Application H16-0767-23
Location Former Bull And Monkie Church Gate Spalding PE11 2RA
Proposal Demolition of vacant former public house and erection of 88 bed care home including onsite parking amenity space and associated works.

Name Diane Fairchild
Address Conservation Assistant (Tree Preservation) Planning & Development

Date Submitted 18-02-25
For/Against Comments

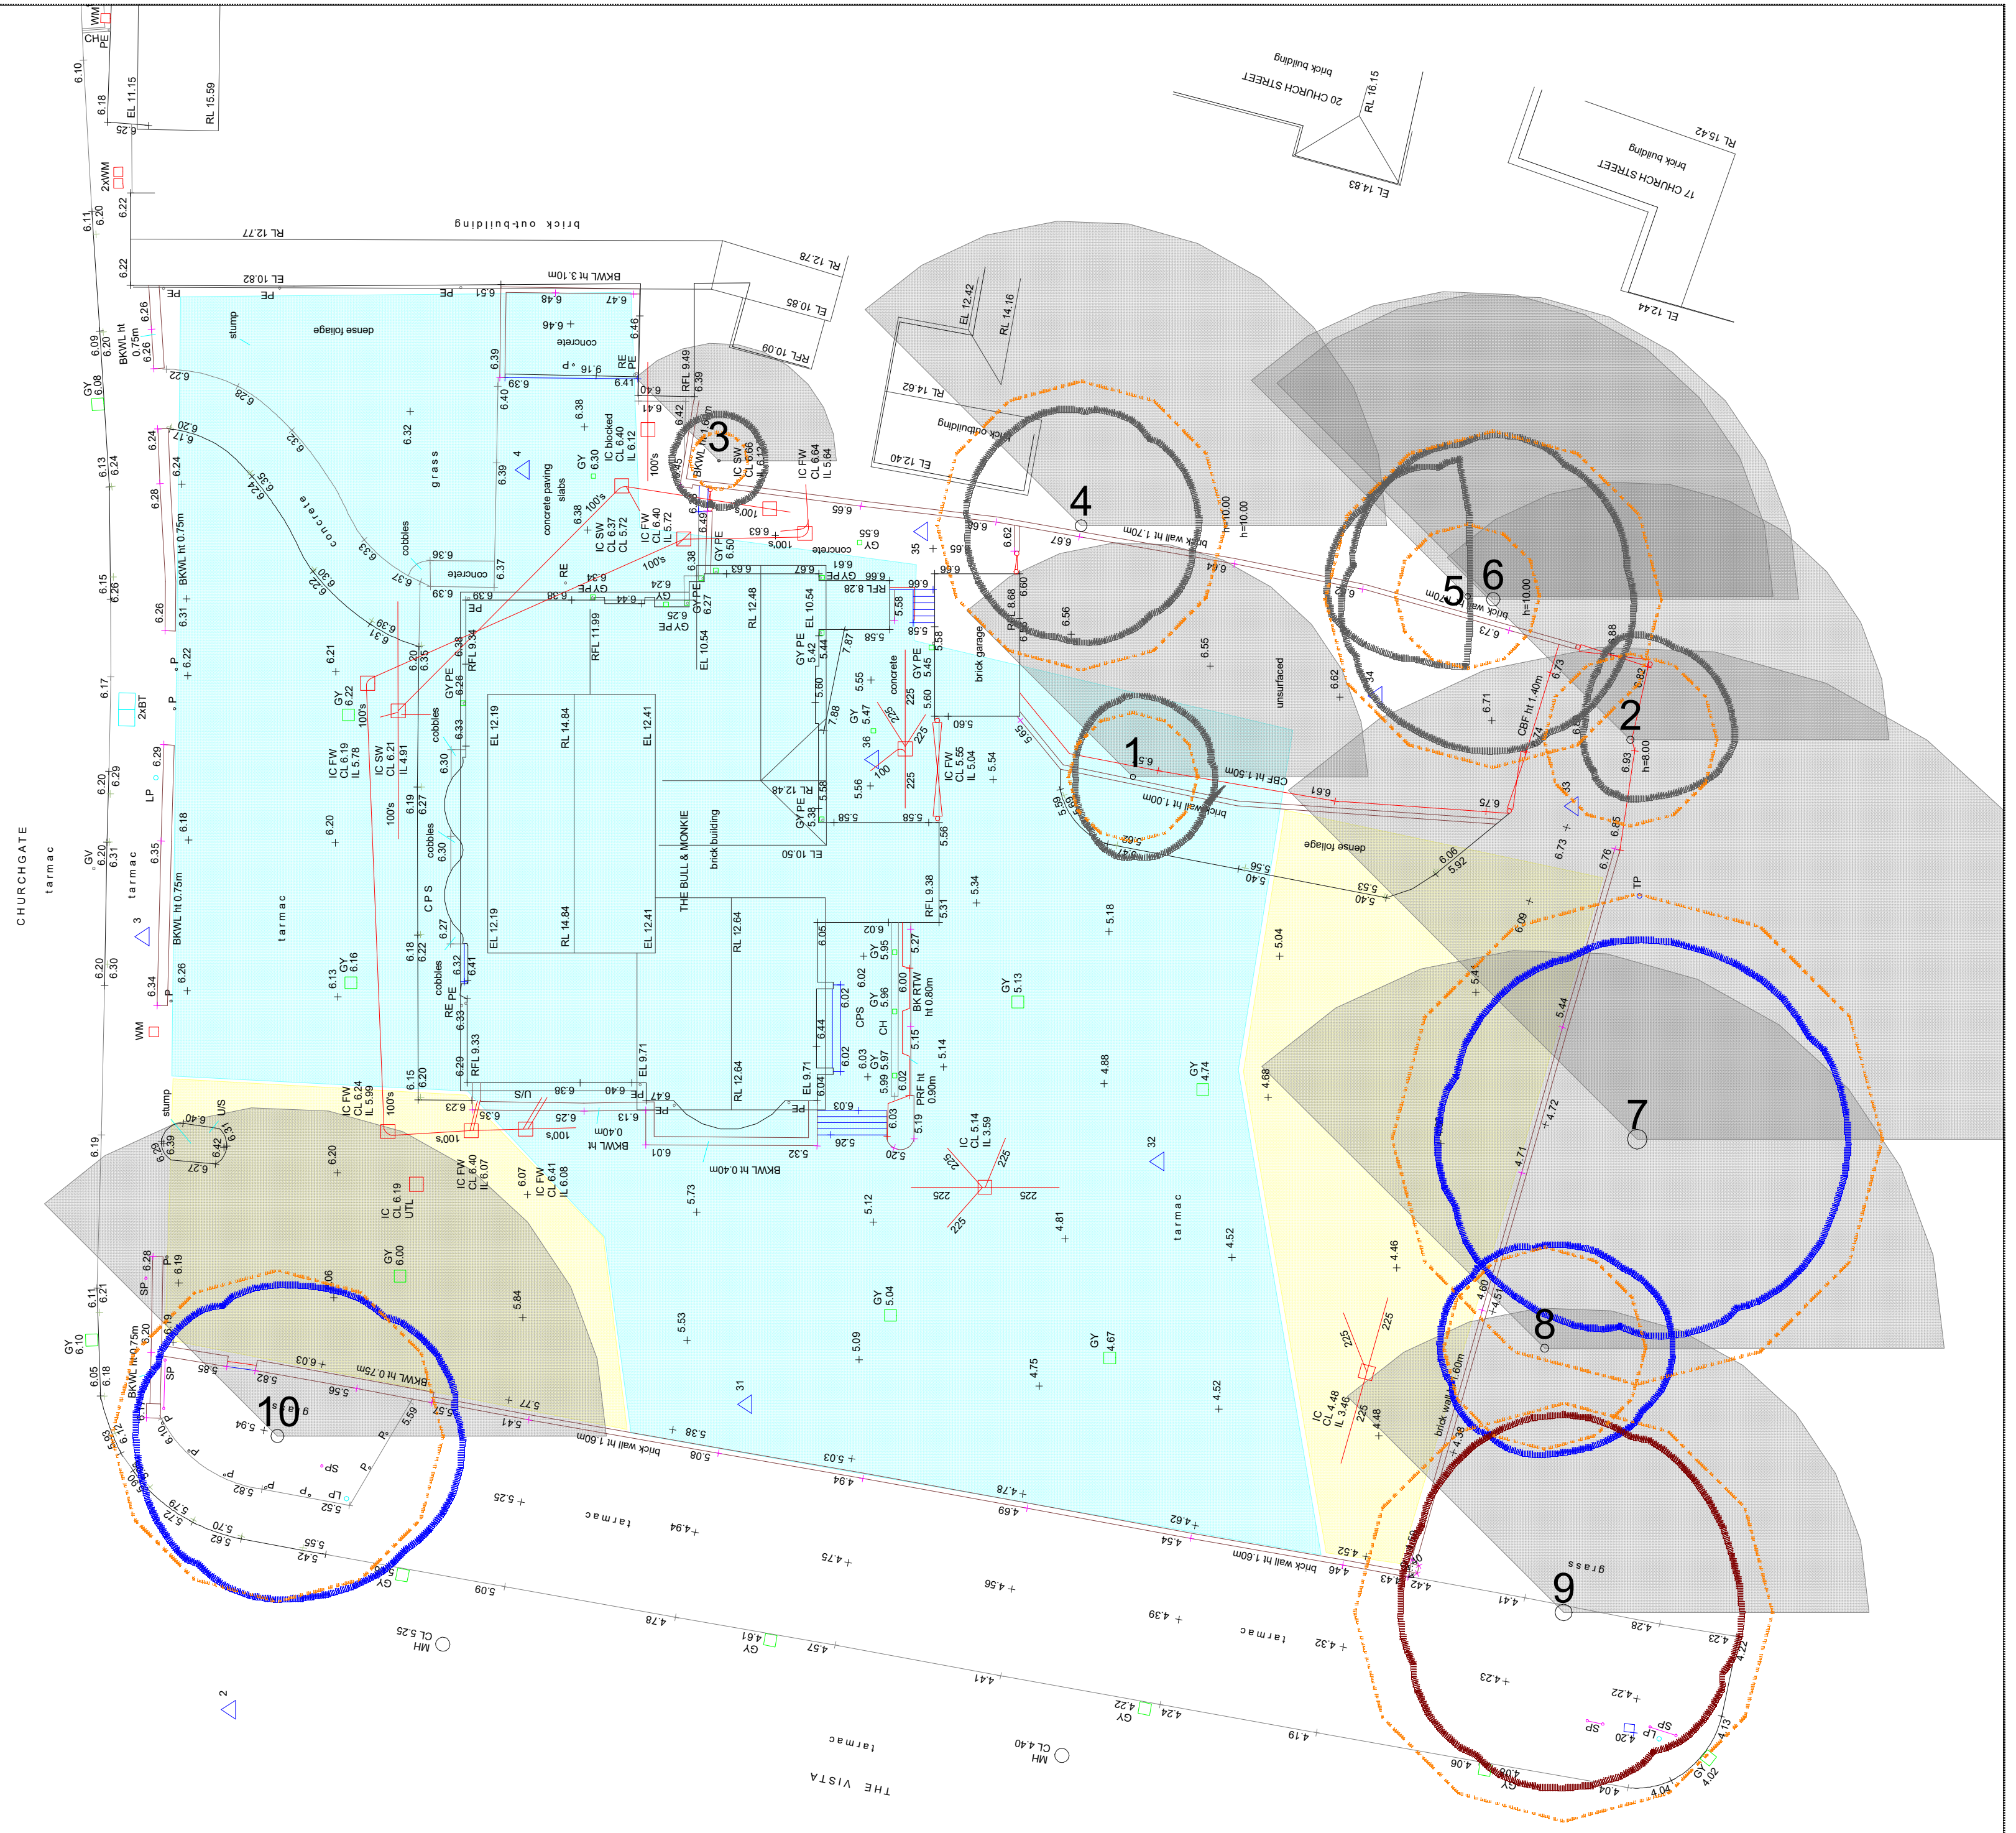
Hope consideration has been given how protective fencing is going to be erected around the Root Protection Areas of trees adjacent to the site to British Standard BS 5837: 2012 and still allow space for the scaffolding required during construction.

The development is exceptionally close to trees which are of high visual amenity value in the middle of Spalding Conservation Area. Trees grow in size, and there is little space between the proposed building and the adjacent trees which are off site. They are likely to shade some of the rooms in the proposed property and obstruct views from windows. Gutters are likely to be filled with detritus from them. More space between the proposal and the existing trees would be beneficial for a long term harmonious existence.

All patios, paths, car parking spaces and other hard standing areas such as around the water pumping station, within the Root Protection areas of adjacent trees, must be constructed using permeable materials using a 'No-dig' construction.

Need for protective ground cover to be installed if any encroachment in Root Protection Areas.
